I am writing to make a formal observation for the planning application An Coimisiún Pleanála - **Case reference: PAX12.324290 for Lissinagroagh Wind Farm located in located in the townlands of Boleyboy, Cashelaveela, Cherrybrook, Killea, Coolodonnell, Faughary, Lissinagroagh, Lisdarush, Lugasnaghta, Raheelin, Shasmore, Tawnyfeacle and Tullyskeherny, County Leitrim by FuturEnergy Lissinagroagh DAC.**

Figure 6-28: Locations of Proposed Compensation Measures

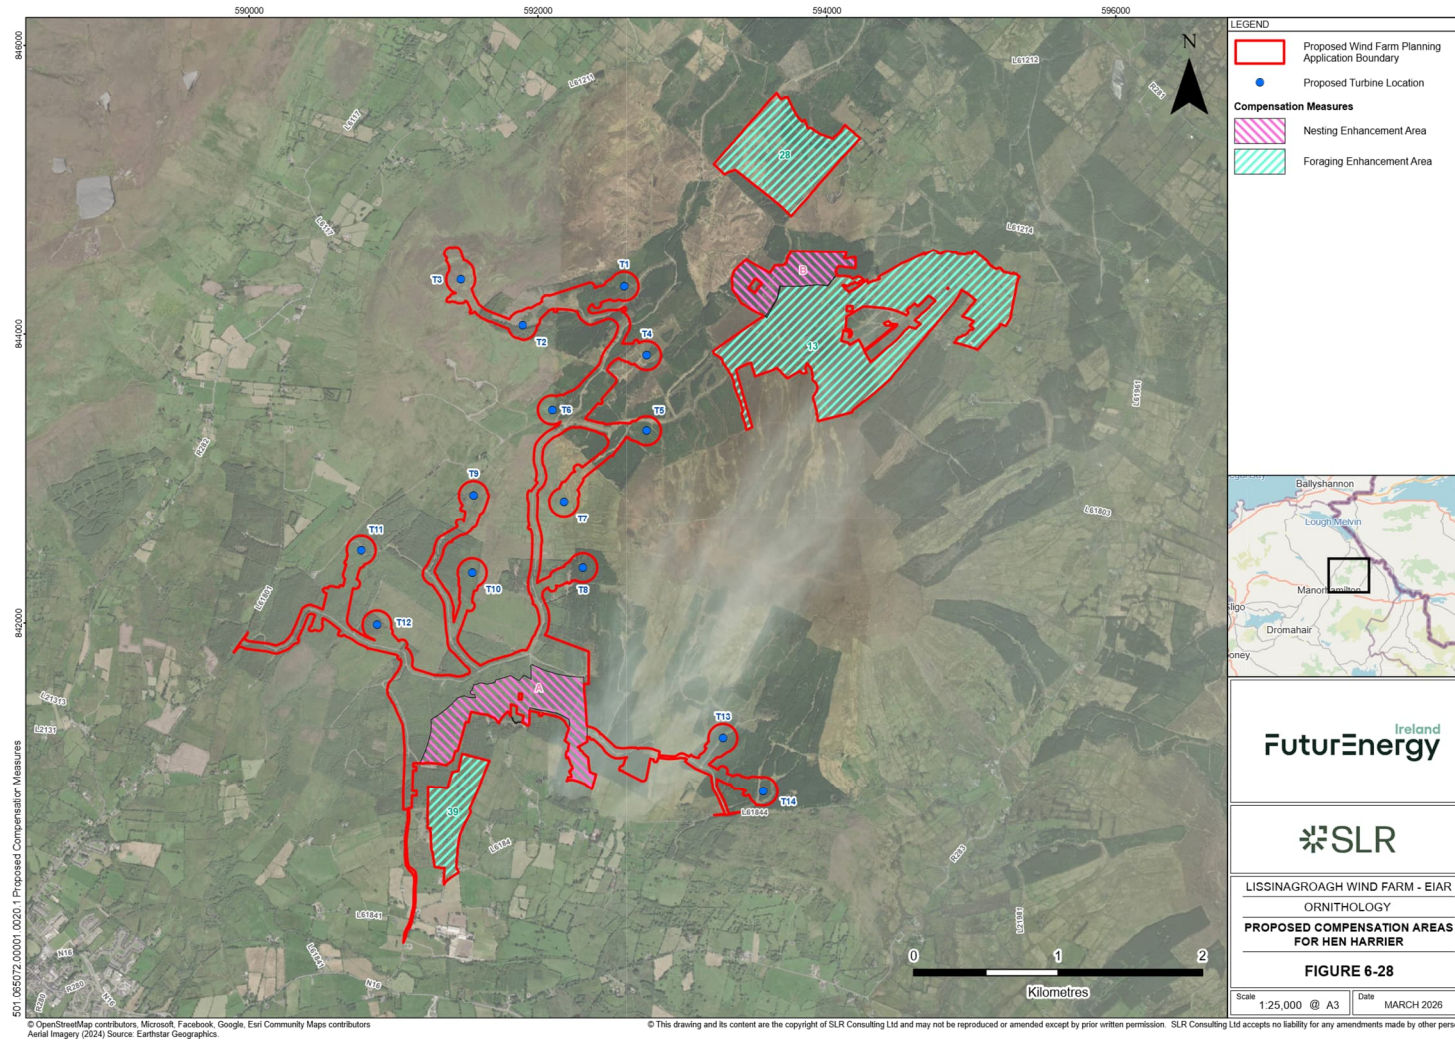
The Hen harriers, buzzards, marsh fritillary butterfly, and red squirrel that all call this place there home, deserve to have their habitat remain unspoiled. I find it abhorrent that the mitigation against hen harrier Turbine strike in chapter 6 table 6.1, are “.... designed to encourage breeding hen harrier away from turbine locations, thereby reducing the likelihood of collision during both foraging and display flights.”
